CITY OF ALBUQUERQUE

Site: Kidz Academy, 10751 Fineland Dr NW

Re: Drainage Ordinance (14-5-2-1) Violations for Erosion and Sediment Control

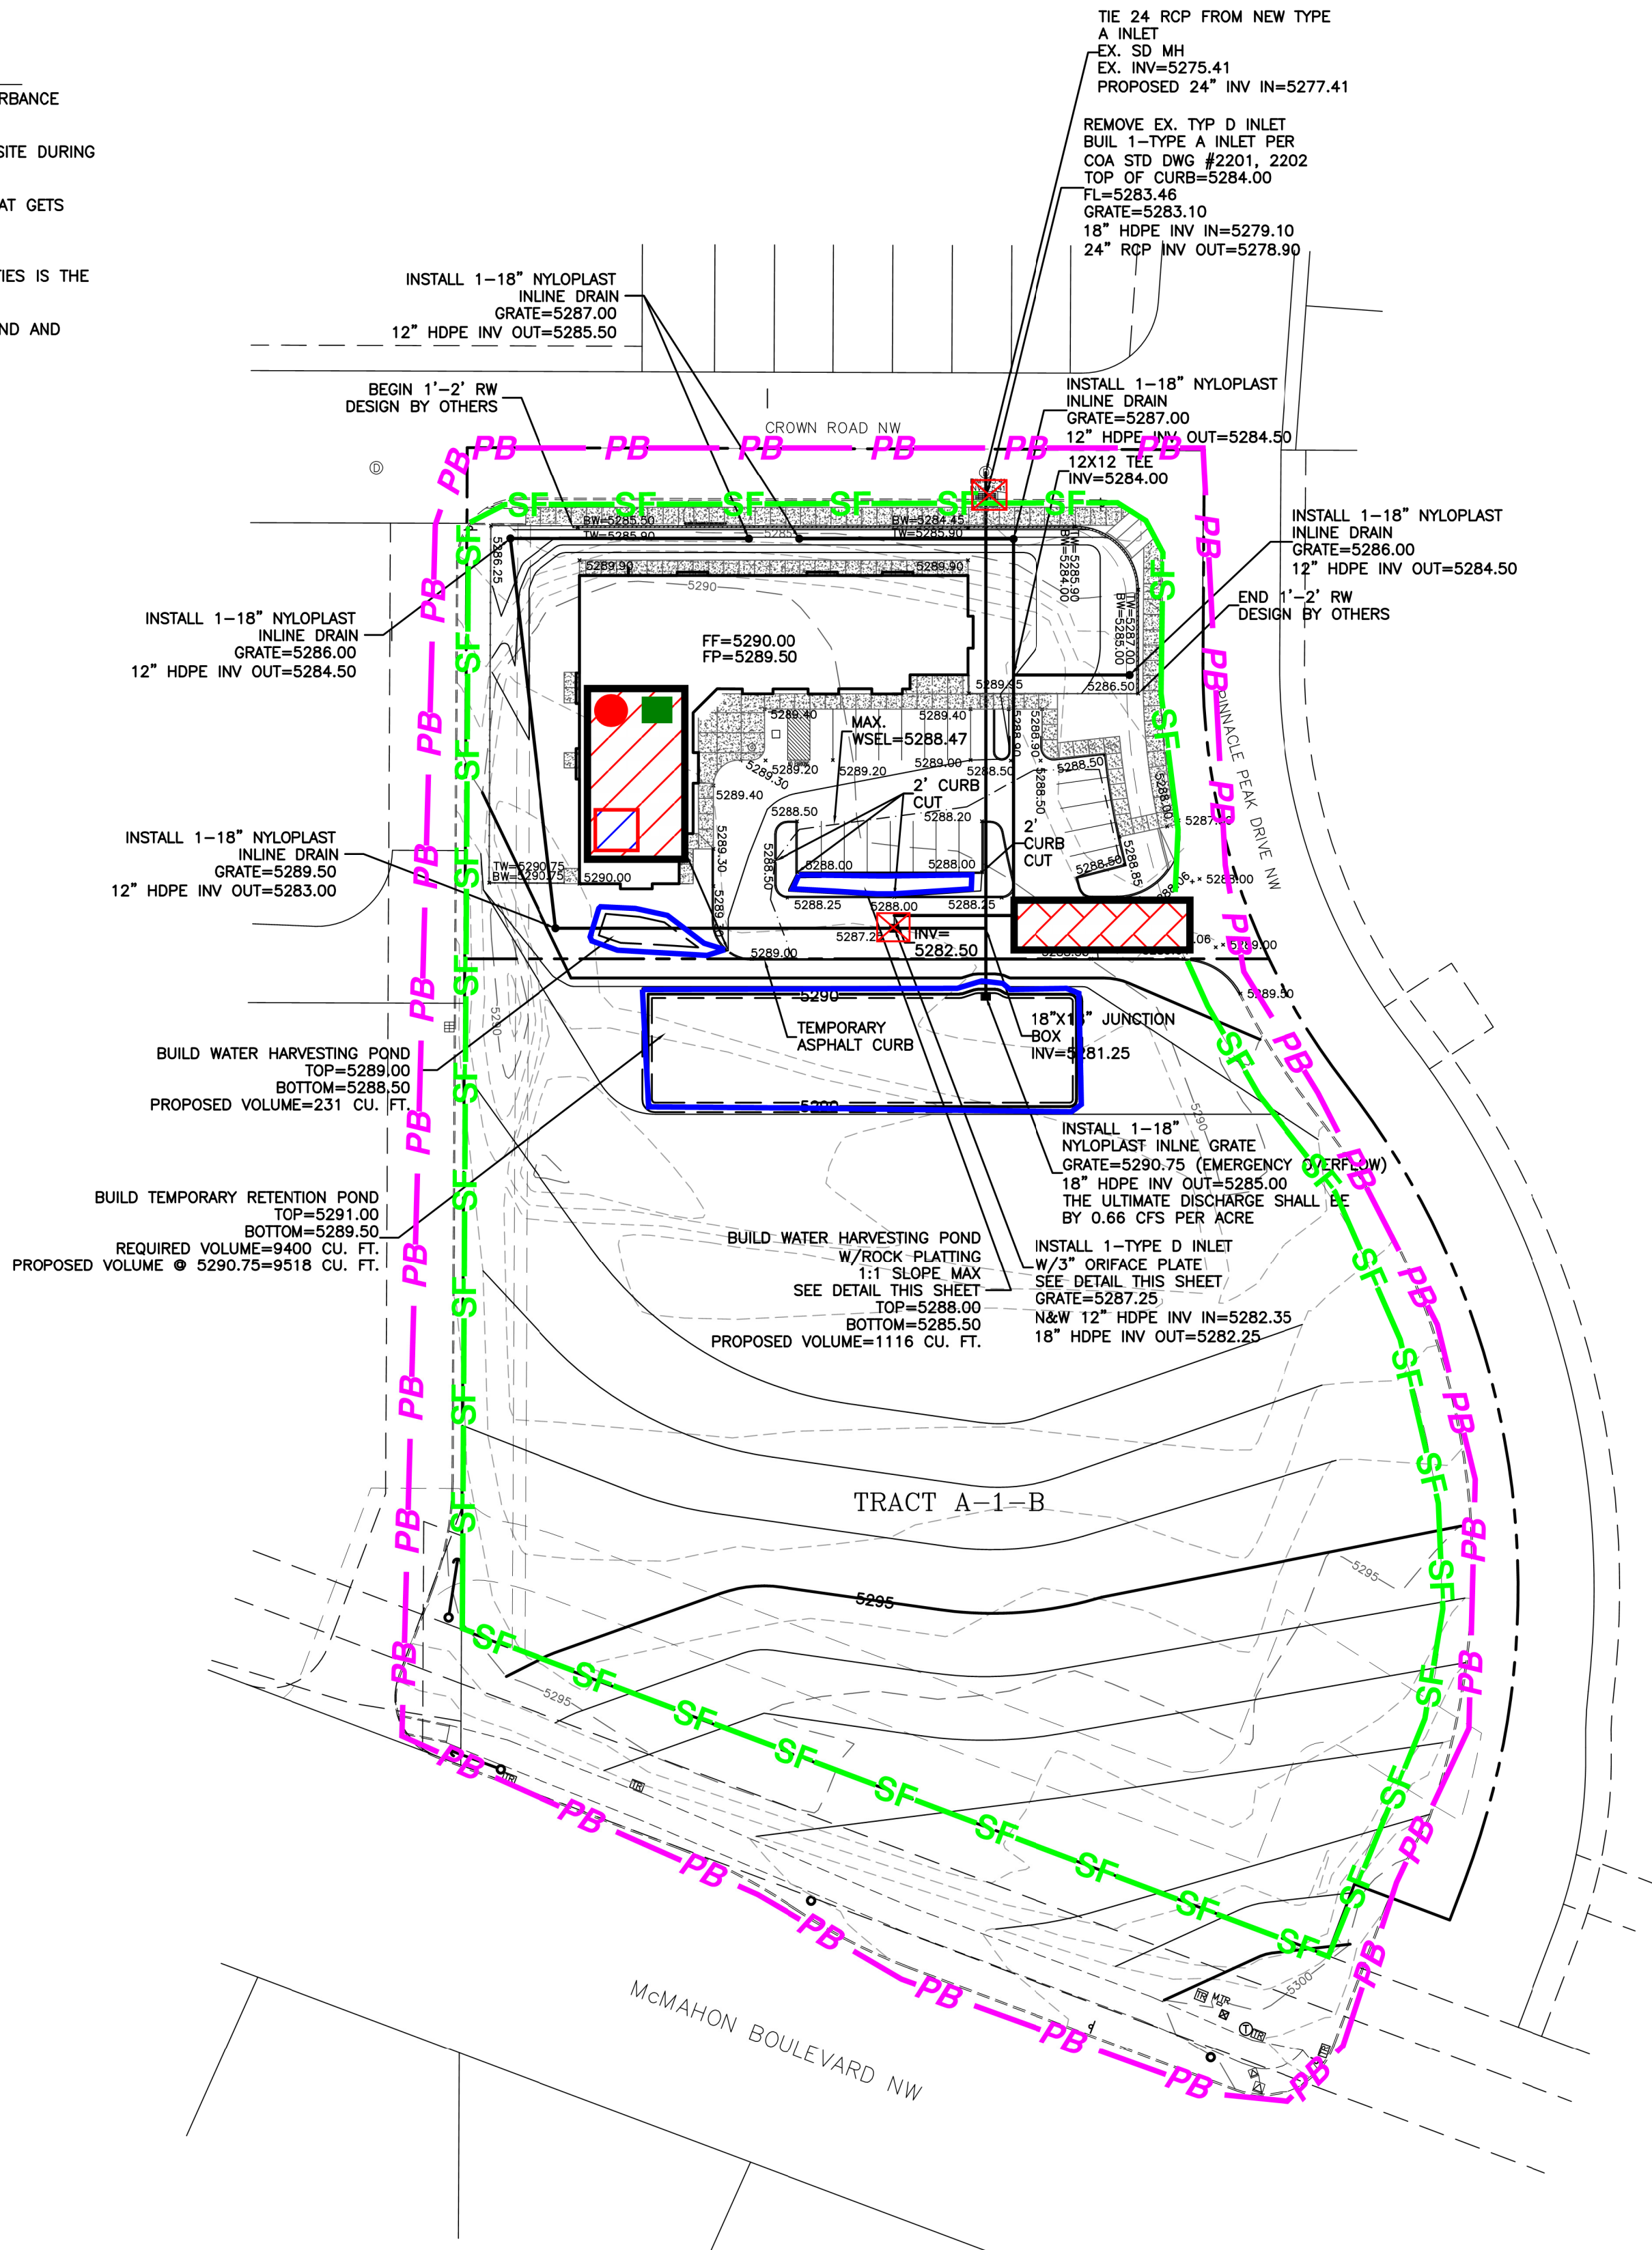
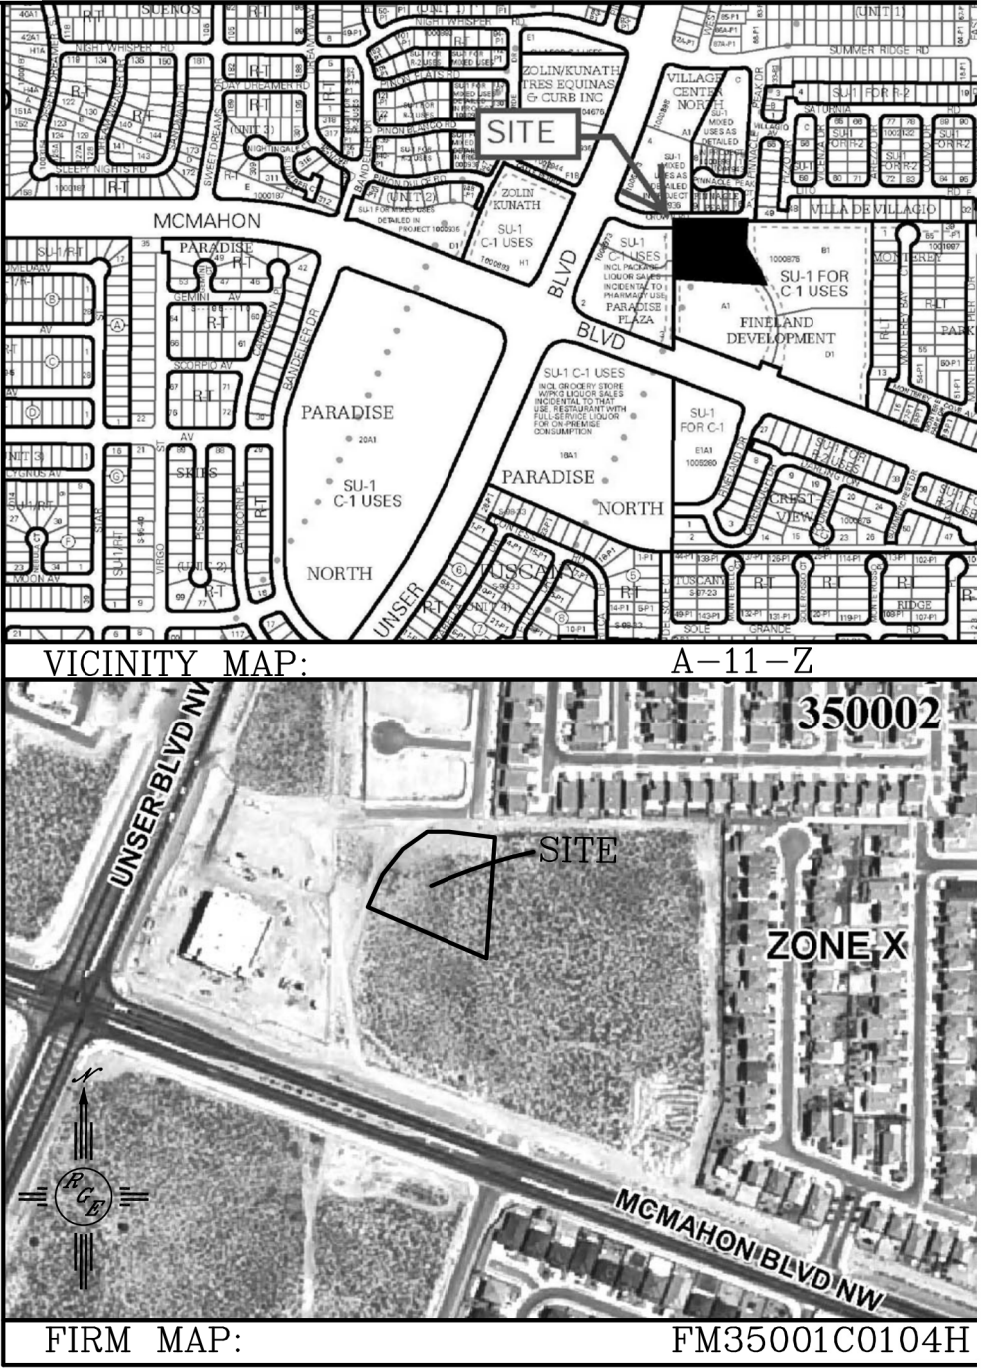
1. A drainage inlet required protection.
2. The silt fence was not buried, bulging and was torn along Fineland Dr. and too much dirt behind the silt fence.
3. Sediment was observed in the gutter pan of Fineland Dr.

Drainage inlet requires protection.

Silt fence gap and silt fence is torn.

Silt fence bulging. Too much dirt behind the silt fence.

Silt fence bulging, too much dirt behind silt fence and sediment in the gutter.

1. Provide protection of the inlet shown in the picture.
2. For the location where the silt fence is not buried the silt fence can be reinstalled so it is buried or a filter sock(s) can be placed at the bottom of it.
3. Where the silt fence is torn, it can be mended, the silt fence reinstalled or a filter sock(s) placed at the bottom of it.
3. Remove sediment from behind the silt fence/curb where the silt fence is bulging. A sediment BMP is required along Finland Dr. Options are: install silt fence/filter socks or lower grade a minimum of 2 inches below top of curb.
